**WELWYN HATFIELD BOROUGH COUNCIL
EXECUTIVE DIRECTOR - PLANNING, PUBLIC PROTECTION AND GOVERNANCE**

DELEGATED APPLICATION

Application No: 6/2019/0652/HOUSE
Location: 9 Holme Close Hatfield AL10 9LQ
Proposal: Erection of single storey rear extension and partial conversion of existing garage
Officer: Ms Emily Stainer

Recommendation: Granted

Drawing No: 4671-P01 Revision:

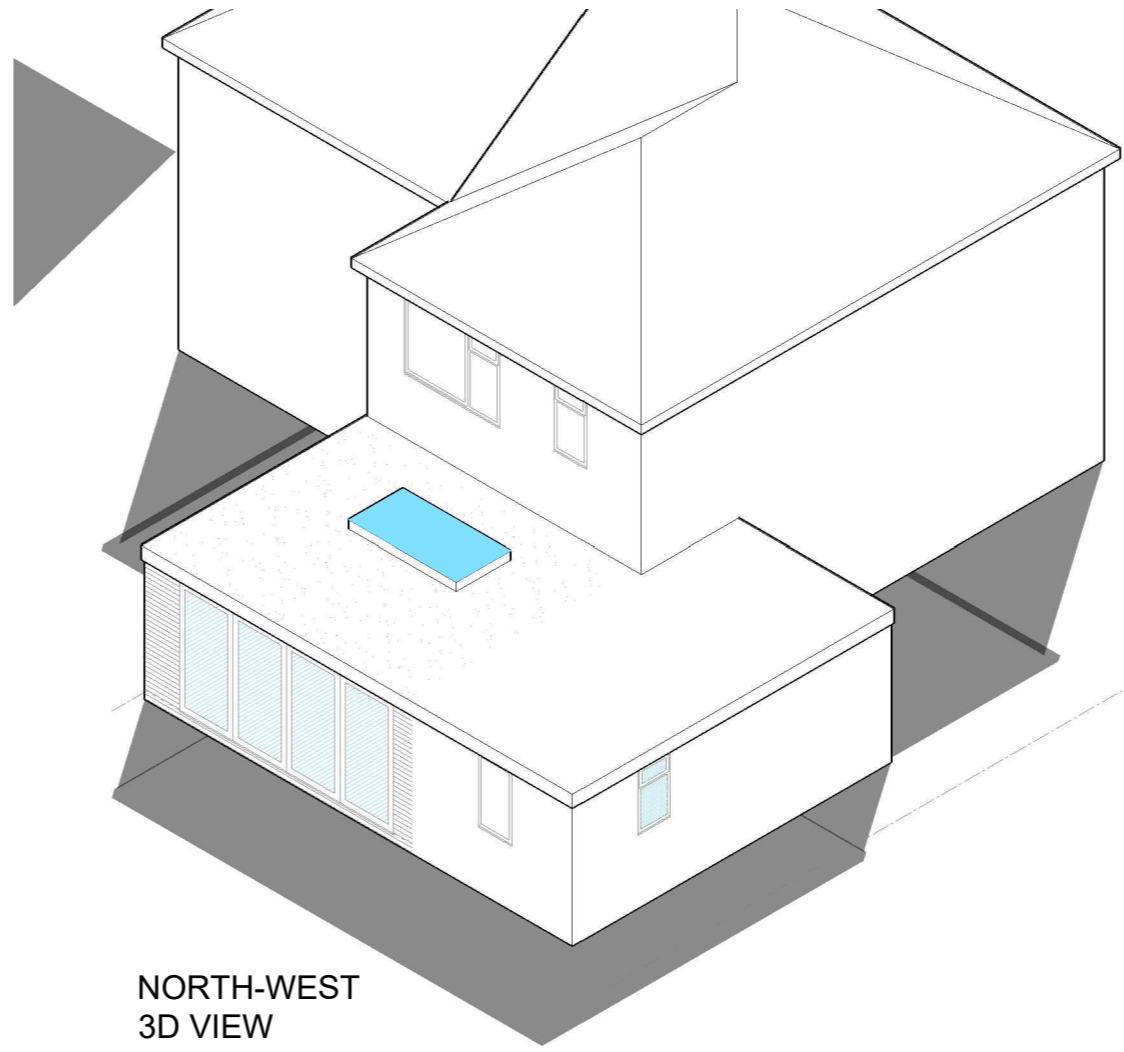
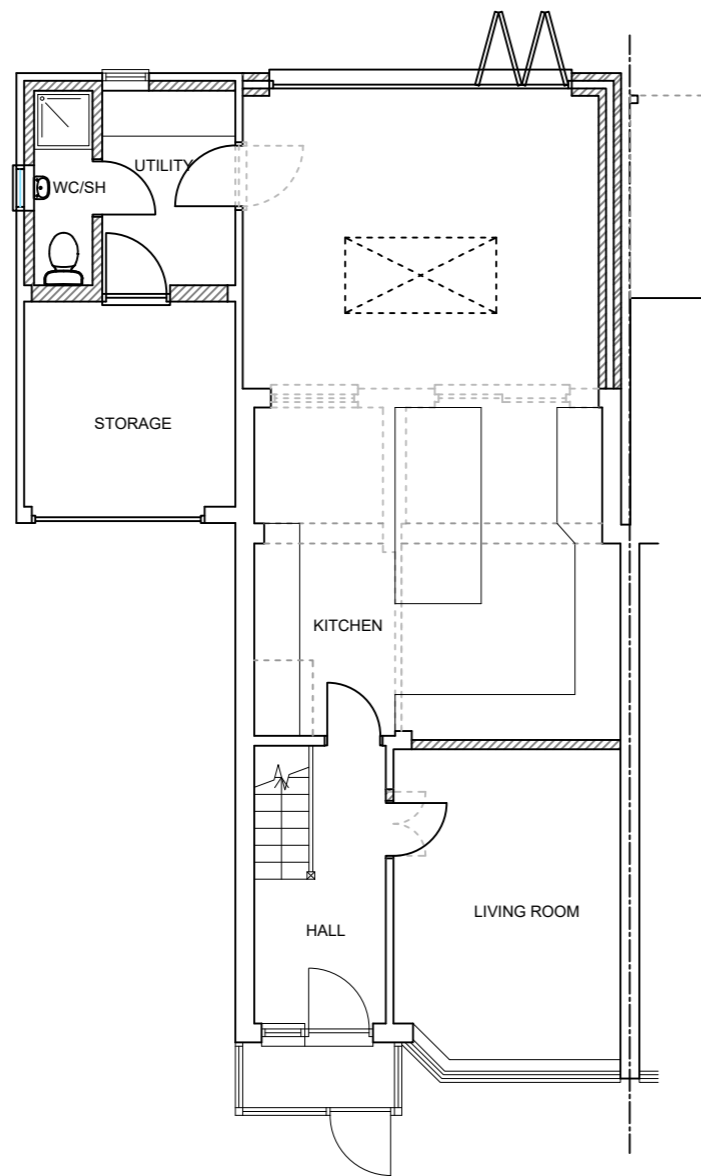
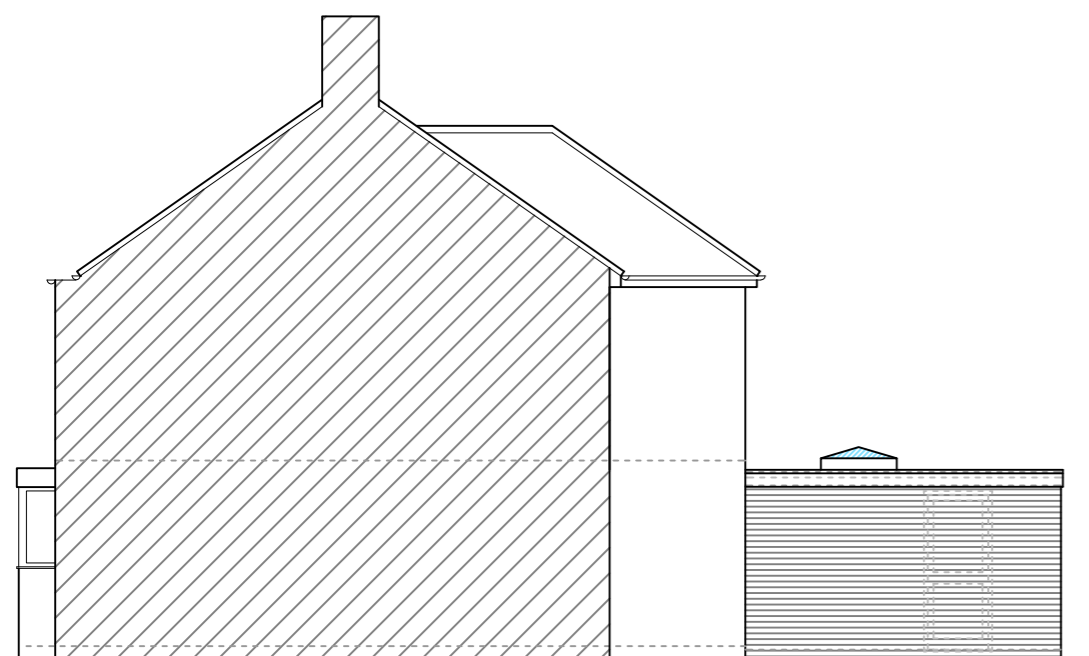
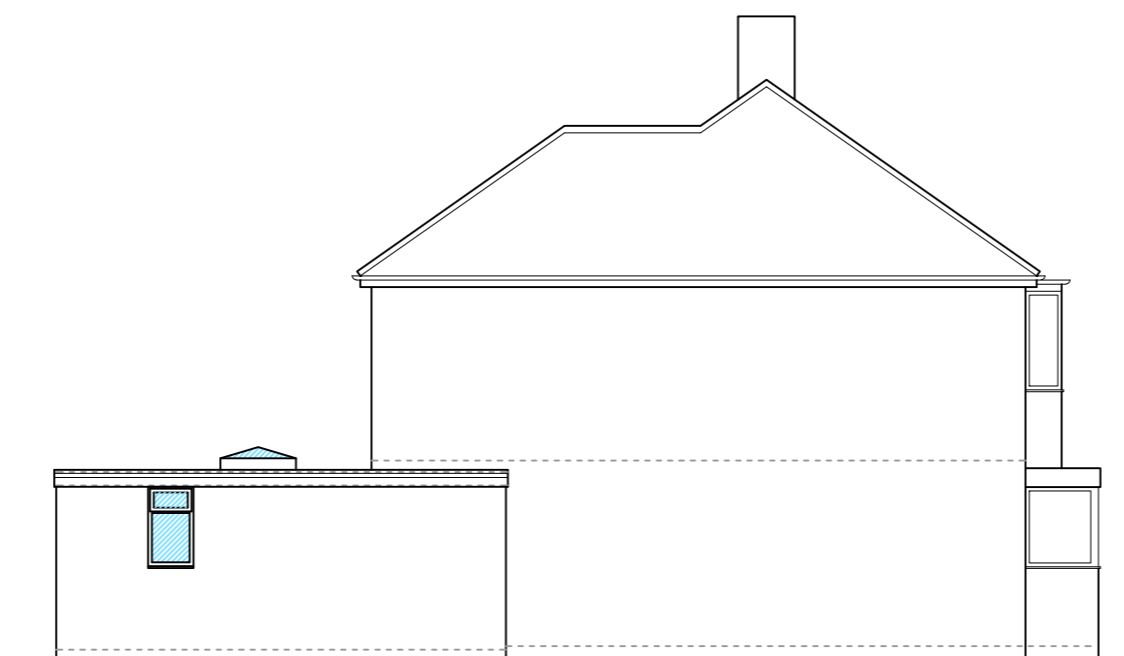
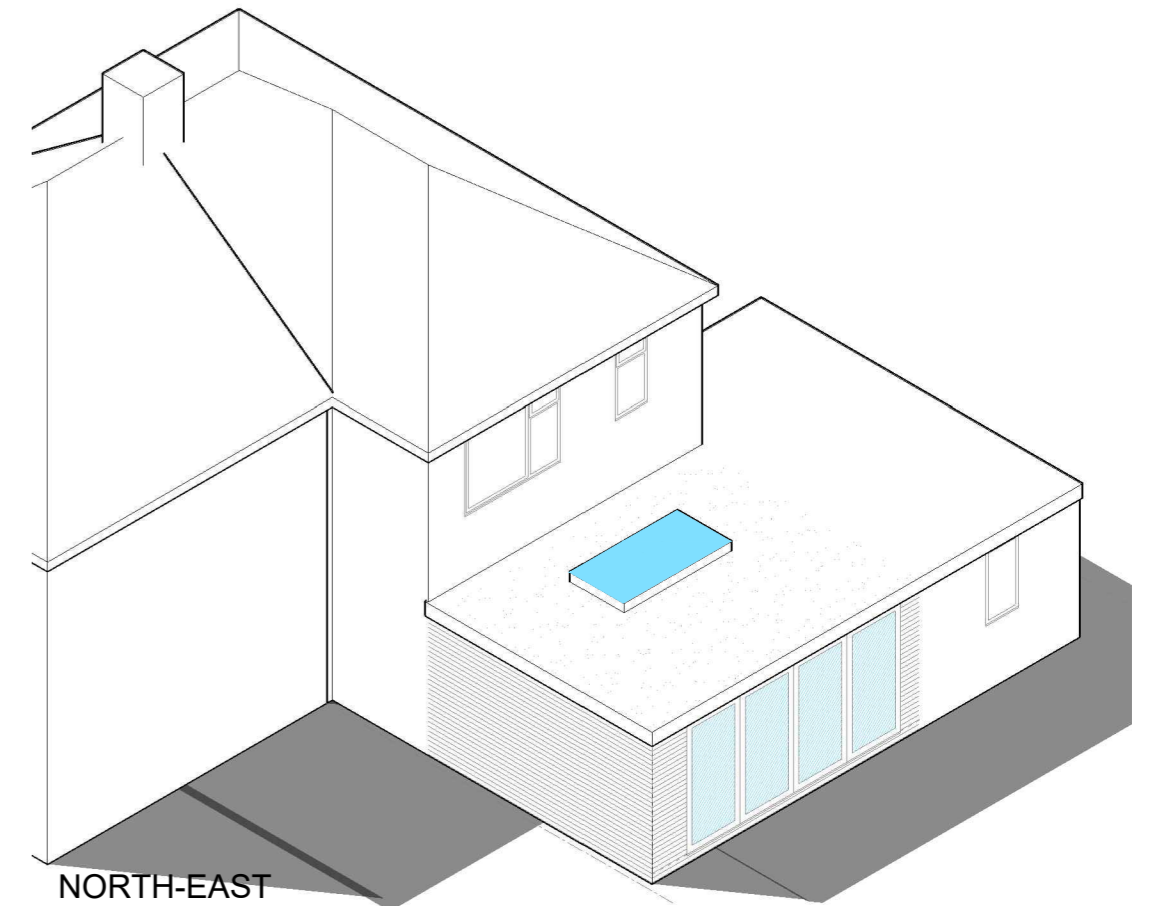
Comment (if applicable):			
The proposal would involve the erection of a single storey rear extension, which would extend across the full width of the property to be in line with the rear wall of the existing garage. The structure would measure approximately 4.1 metres in depth, and 2.5 metres in height. The application dwelling benefits from a spacious garden and the proposed extension would not create a cramped appearance in the size of the plot. The proposed extension would remain subordinate in scale to the dwelling and would relate to the design of the existing dwelling by virtue of its proposed materials. The proposed garage conversion would involve limited alterations to the external appearance of the property, comprising the insertion of a side window. The works would not be unduly visible from the street scene, and as a result would not harm the character of the area or its visual amenity.

By virtue of its flat roof design and modest height, the proposed extension is unlikely to cause a loss of light or appear overbearing to either of the adjoining occupiers. The proposed side window to facilitate the garage conversion would face 9A Holme Close, which is set further back into its site than No.9. The insertion of a window in this location is not considered to result in a loss of privacy, as the only window in the neighbouring property facing the garage serves a staircase to the first floor. It is also located at a higher level than the proposed window.
